SECTION 75W MODIFICATION APPLICATION FOR THE PROPOSED EXTENSION TO KAREENA PRIVATE HOSPITAL MP 08_0169 MOD 1 - 86 KAREENA ROAD, CARINGBAH

This letter responds to an email from the Department dated 01 March 2013 requesting additional information and clarification on inconsistencies between the submitted documentation and the original approval. These matters are addressed below.

Proposed Ground Floor Plan

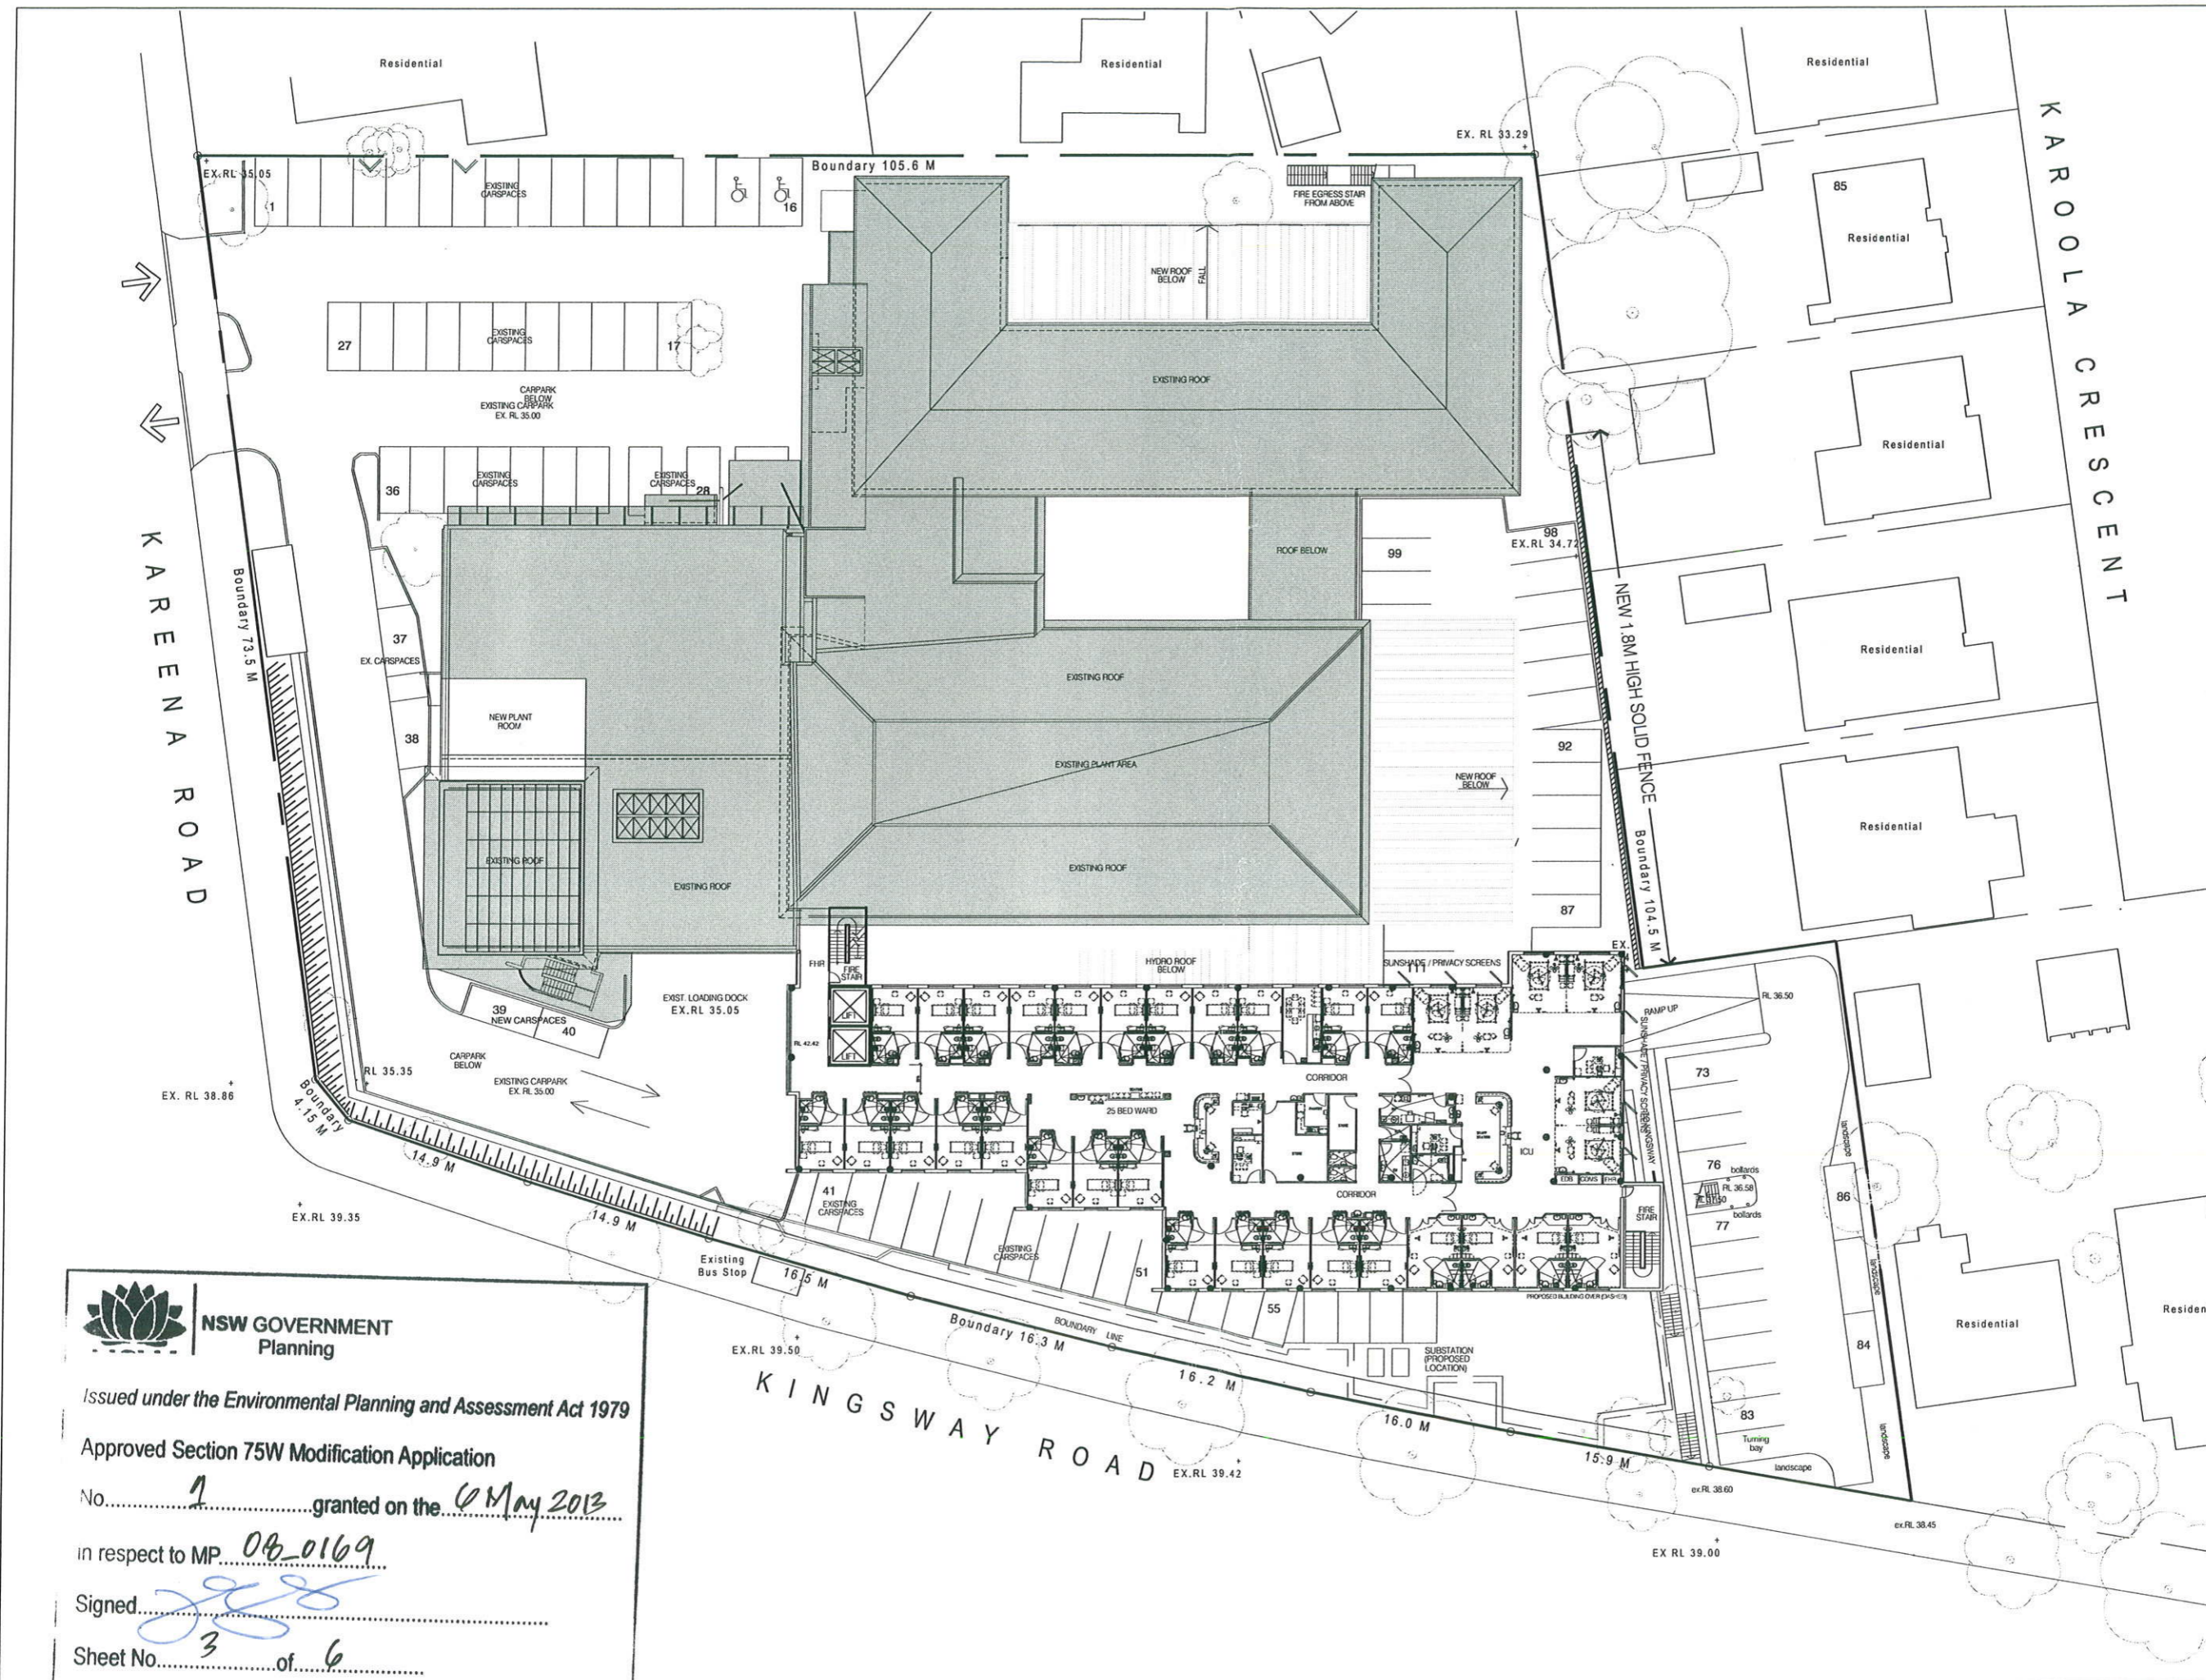
The Proposed Ground Floor Plan (Dwg No. KPH-P-1c Rev 1) has been amended to maintain consistency with the car parking layout on the approved Ground Floor Plan (Dwg No. PSA 7536-DA08 Rev J). There is no change to the number or design of approved car parking spaces proposed under the subject modification application.

The Proposed Ground Floor Plan (Dwg No. KPH-P-1c Rev 1) has been amended to maintain consistency with the loading bay and turning facility layout on the approved Ground Floor Plan (Dwg No. PSA 7536-DA08 Rev J). There is no change to loading and unloading areas or vehicle circulation arrangements within the site under the subject modification application.

The Proposed Ground Floor Plan (Dwg No. KPH-P-1c Rev 1) has been amended to maintain consistency with the landscaped areas on the approved Ground Floor Plan (Dwg No. PSA 7536-DA08 Rev J). There is no change to approved landscaping within the site under the subject modification application.

SITE PLAN - SHADOW 21 DECEMBER 3PM

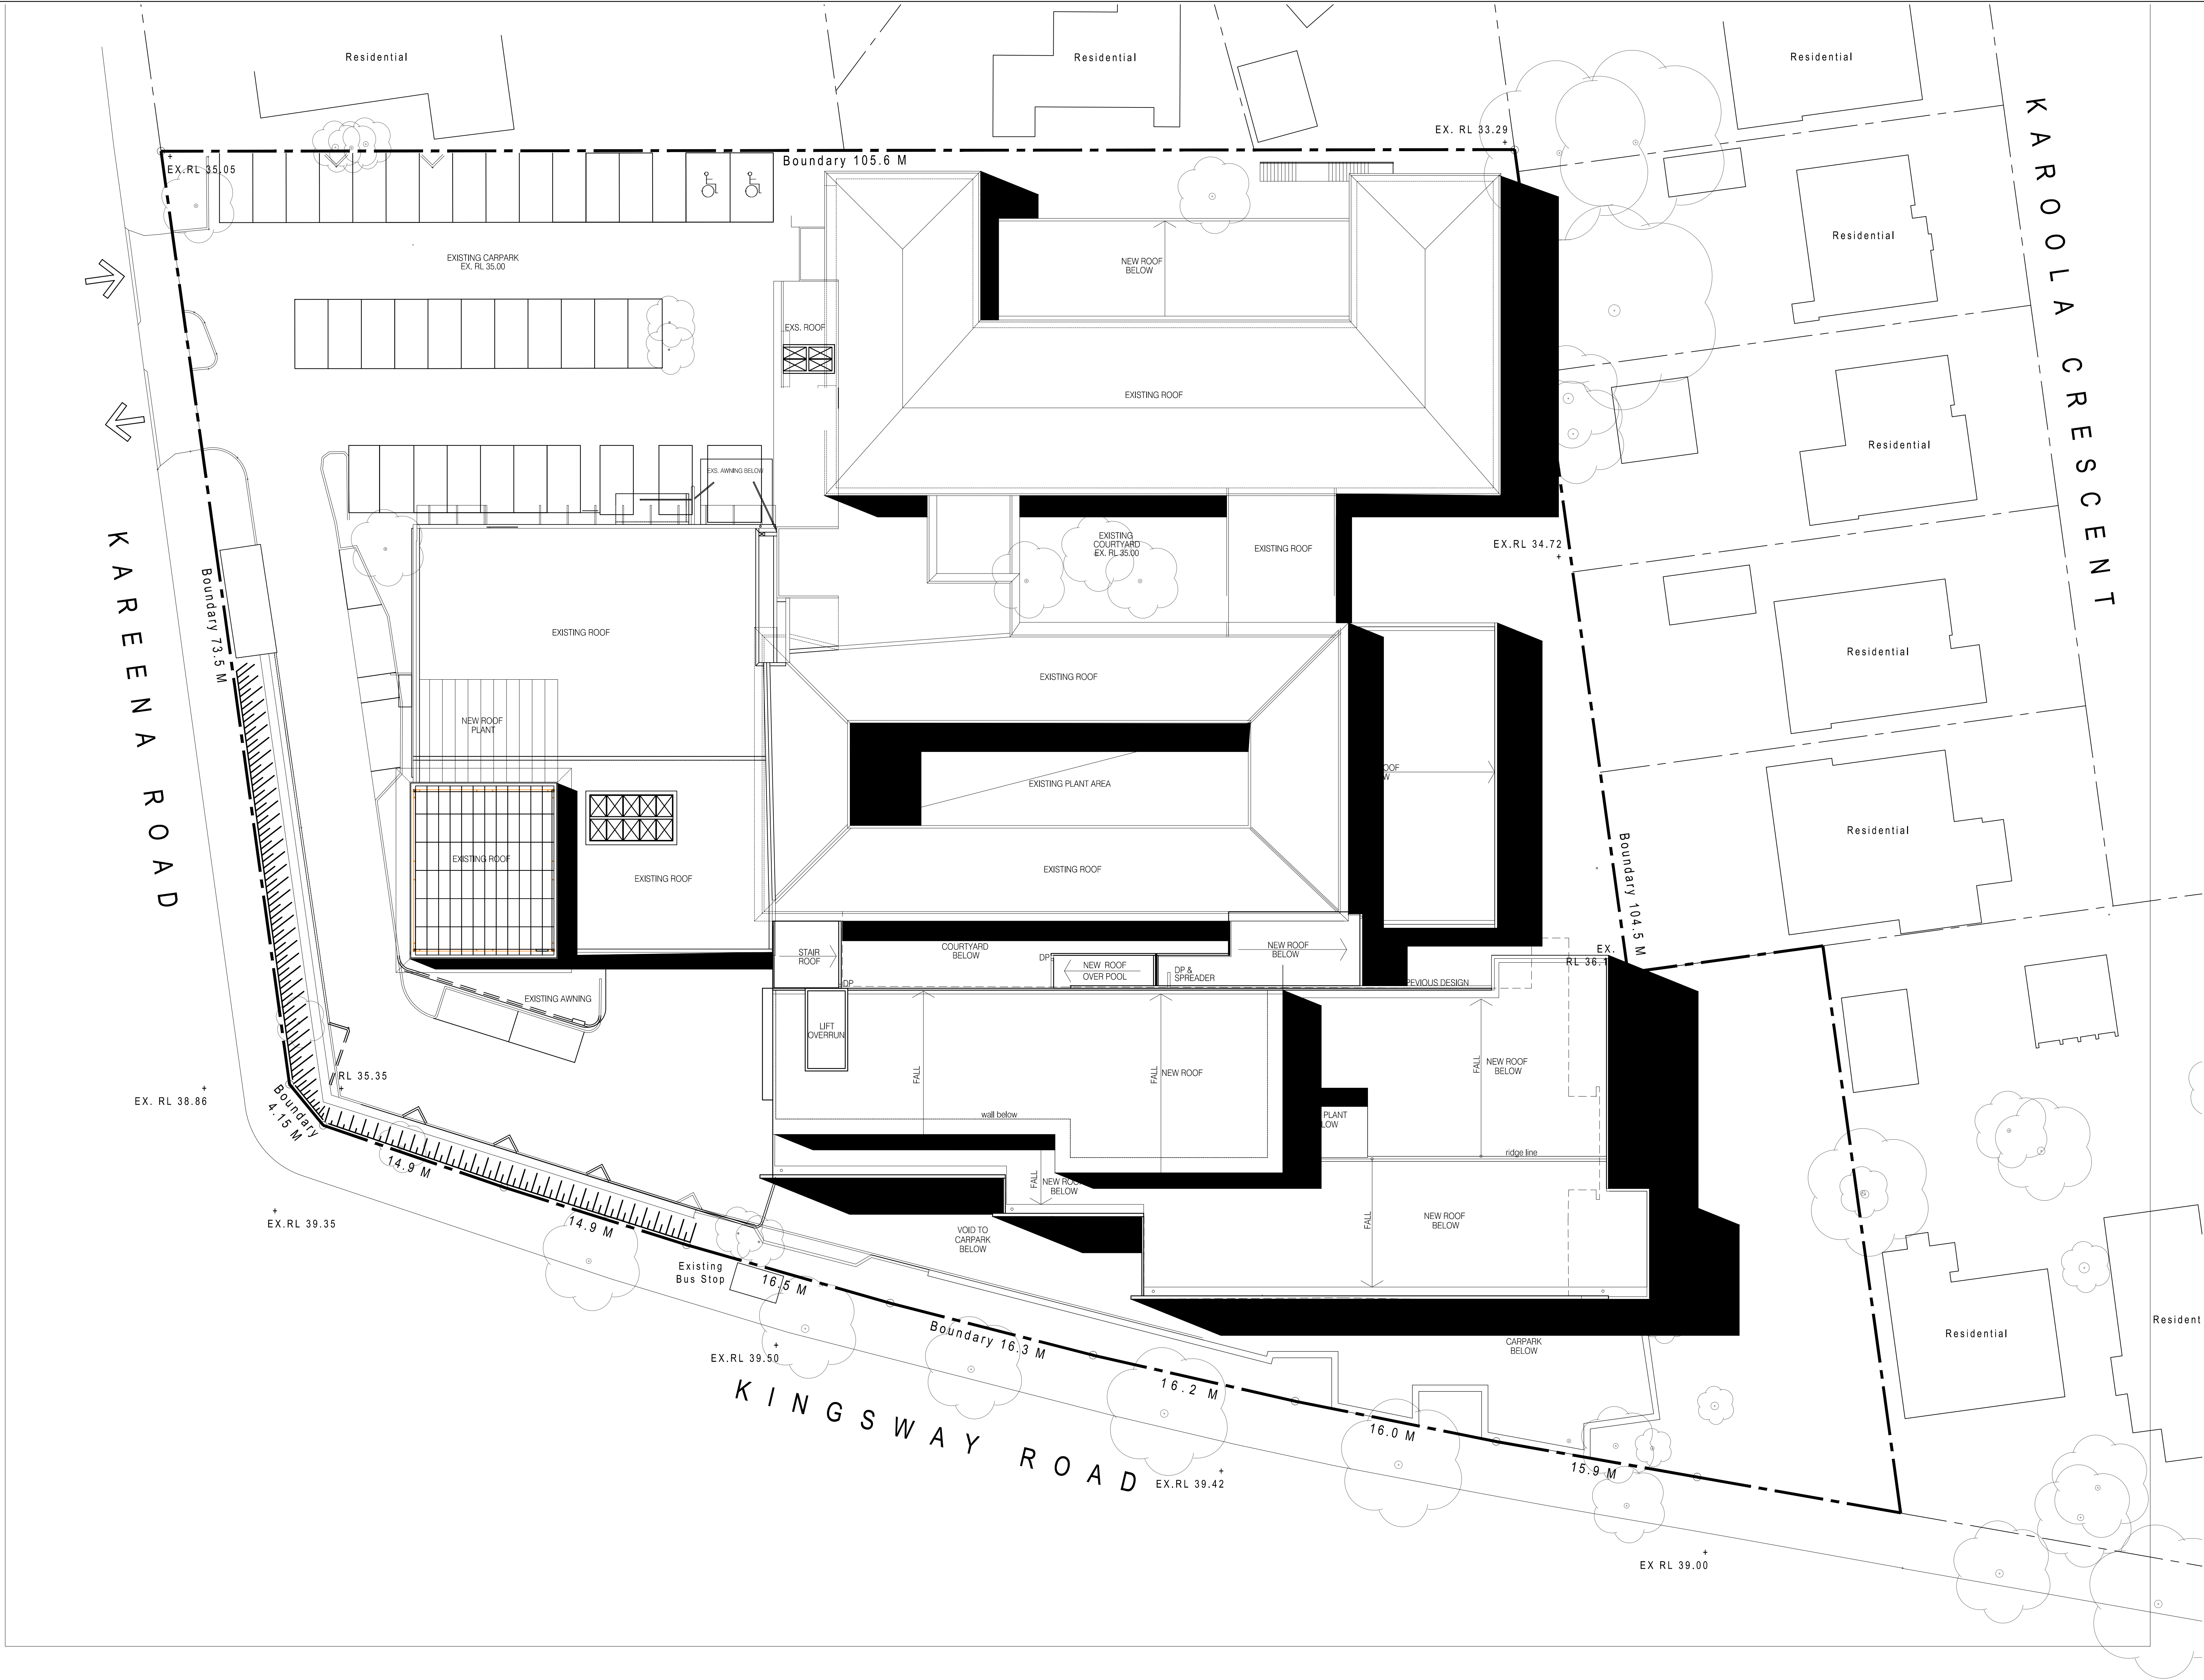
Shadow Diagrams have been prepared incorporating the proposed extension to illustrate the impact on adjoining residential properties. The Shadow Diagrams show shading at 3pm 21 December (Dwg No. KPH-P-SHAD Rev 1) and shading at 3pm 21 June (Dwg No. KPH-P-SHAD Rev 1).

The area which is subject to the proposed extension is the Ground Floor (middle building). This part of the Hospital is substantially setback from the adjoining residential boundary. The proposed extension to the building, over the carpark, will not result in any significant overshadowing impacts to the adjoining residential properties.
